From: Sue Howell
Sent: 08 December 2014 14:18
To: Planning.Responses
Cc: Peter Cleveland
Subject: RE: Planning Consultation on: A/154/14/OUT

Comments from Greenspace

APPLICATION **A/154/14/OUT**

Site Address: Pound Place Roundstone Lane Angmering BN16
4AL

SITE PLAN

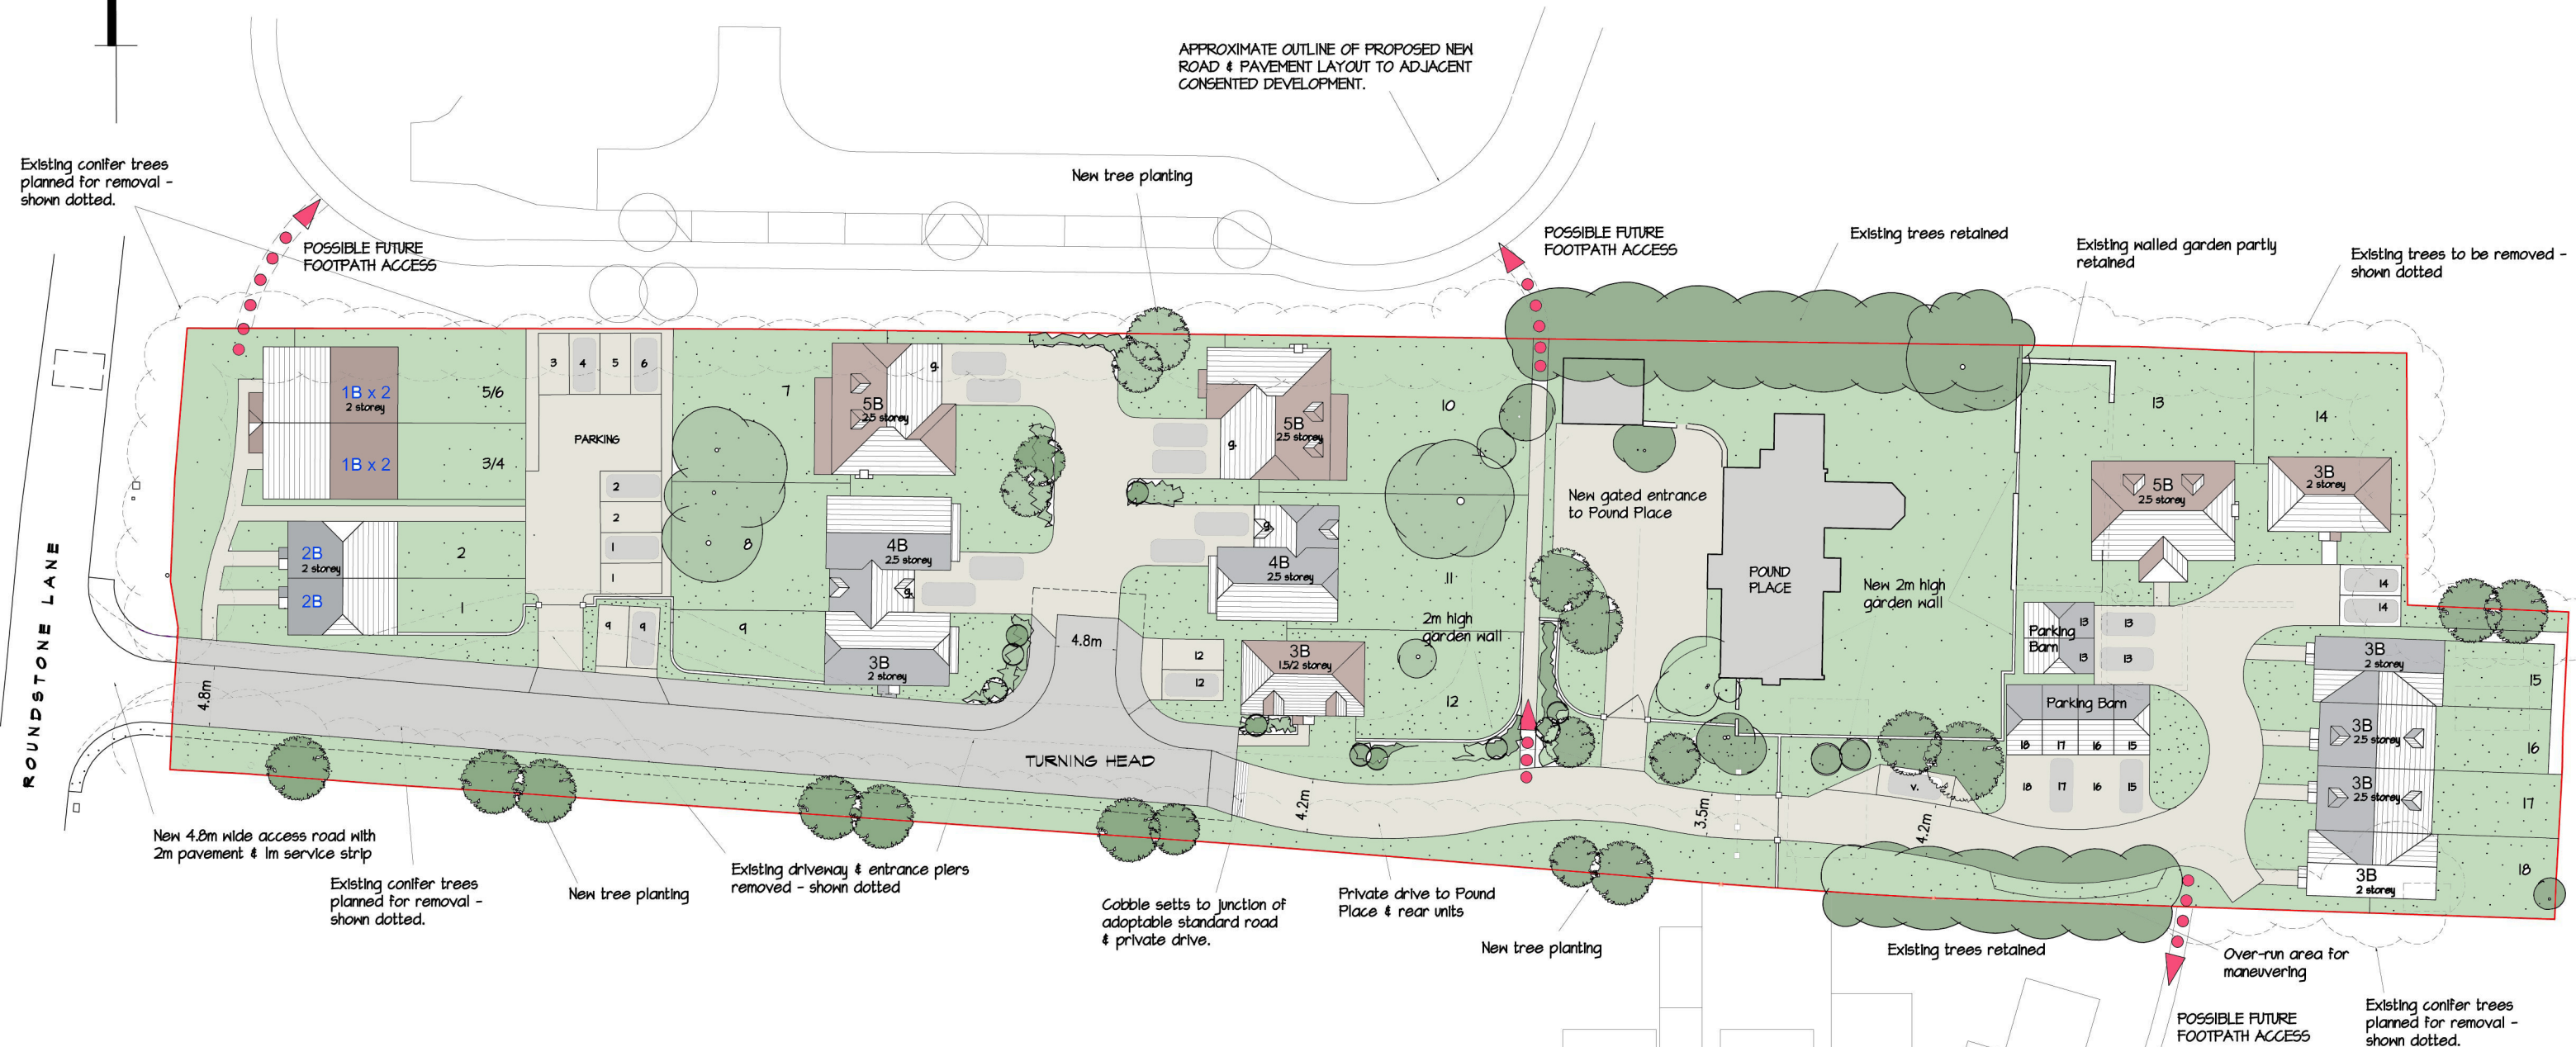
Forming part of the application and prior to any consent being given a full landscape scheme should be submitted for approval, detailing species choice, position, densities and size at time of planting. This should be plotted in plan and list form and in relation to the trees and vegetation to be retained in the locale, so that a clear picture of the proposals can be seen. These details are required to assure the adjacent land setting is maintained, the setting is uncompromised and the proposals are appropriate to its setting.

Any trees or vegetation that fall within the proposed or periphery of the development, may provide significant aesthetic impact to the location. Any trees in particular along the boundaries, which adjoin neighbouring land could provide potential valuable screening and should be retained particularly those adjoining the settlement boundary. Any considered tree removal from this site should be agreed with Arun District Councils Tree Officer. Root protection Areas (RPA) should extend into the development site and to those in neighbouring land. Before construction, a tree protection scheme must be in place for any (If any) retained trees including trees whose root protection areas fall within the construction zone from neighbouring land. This should be in accordance with BS 5837:2012 'Trees in relation to construction' Any removed trees should be mitigated for allowing for inclusion of native species for biodiversity purposes and fitting to the semi-rural setting.
